# Broken Hill City Council

August 6, 2010

**Subject: Part 3A Application by Broken Hill Operations Pty Ltd**  
**Your Ref: Rasp Project (07\_0018)**

Broken Hill City Council wishes to make the following submission in relation to this particular application.

Figure 14-2 Trucking route through Broken Hill

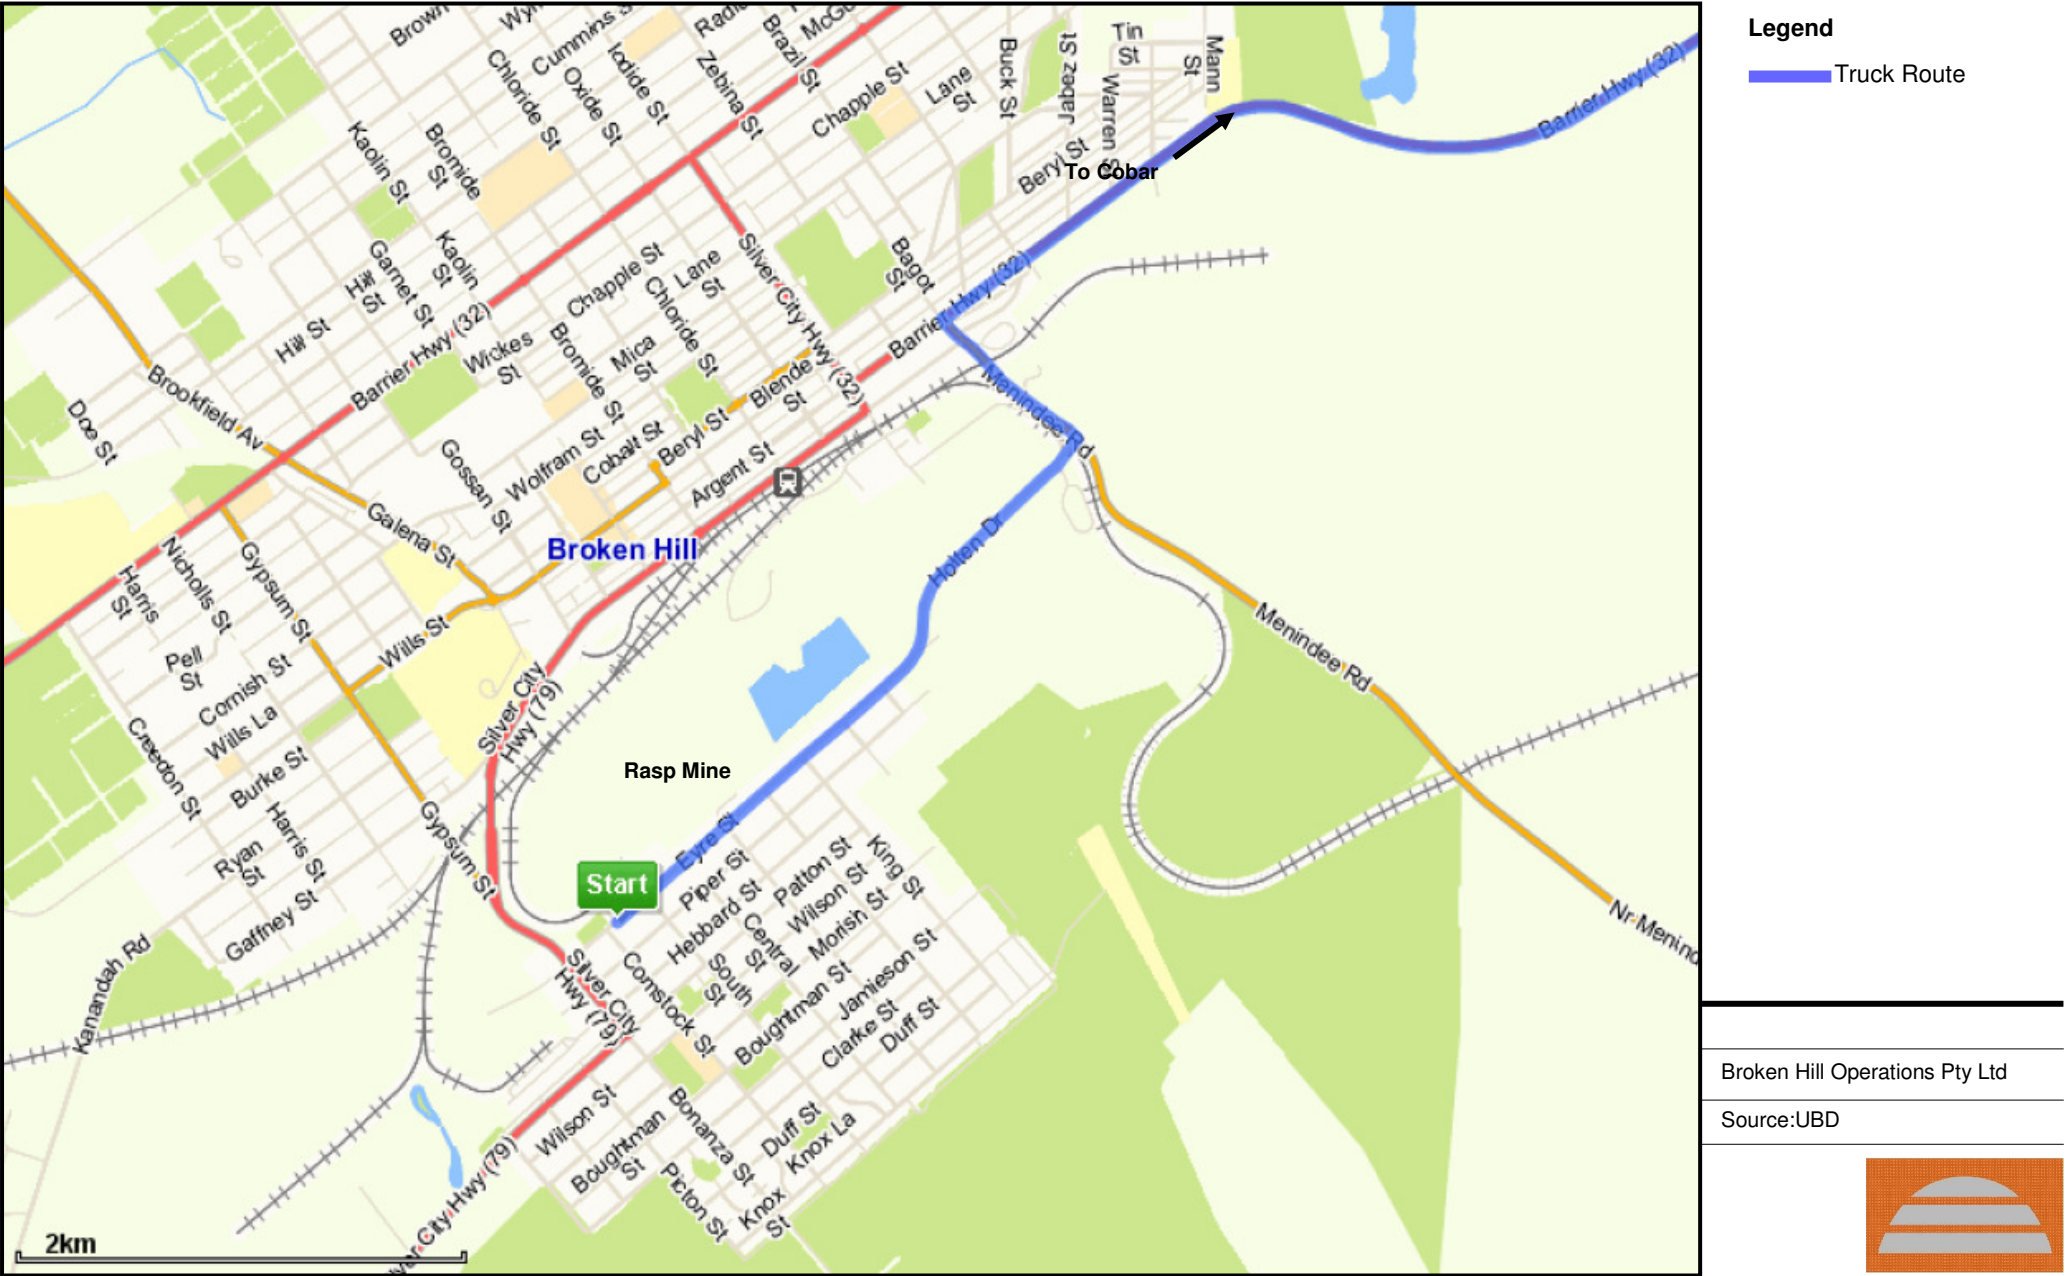
The access to the site from Eyre Street should be assessed to determine the capability of the existing road pavement to withstand the intended road traffic movements. Any upgrading of the road pavement should be at the full cost of the developer. Any ongoing road maintenance issues in relation to this development should also be the responsibility of the developer.

The access to the site should also be assessed to determine the need for traffic management devices to be installed to ensure that all traffic movements can be carried out safely to ensure that all vehicles can satisfactorily queue and carry out turning movements without crossing the entire line of the road or without causing other traffic management issues. Particular attention should be directed to heavy vehicle turning movements from Eyre Street in a westerly direction and any impacts on the Comstock Street intersection.
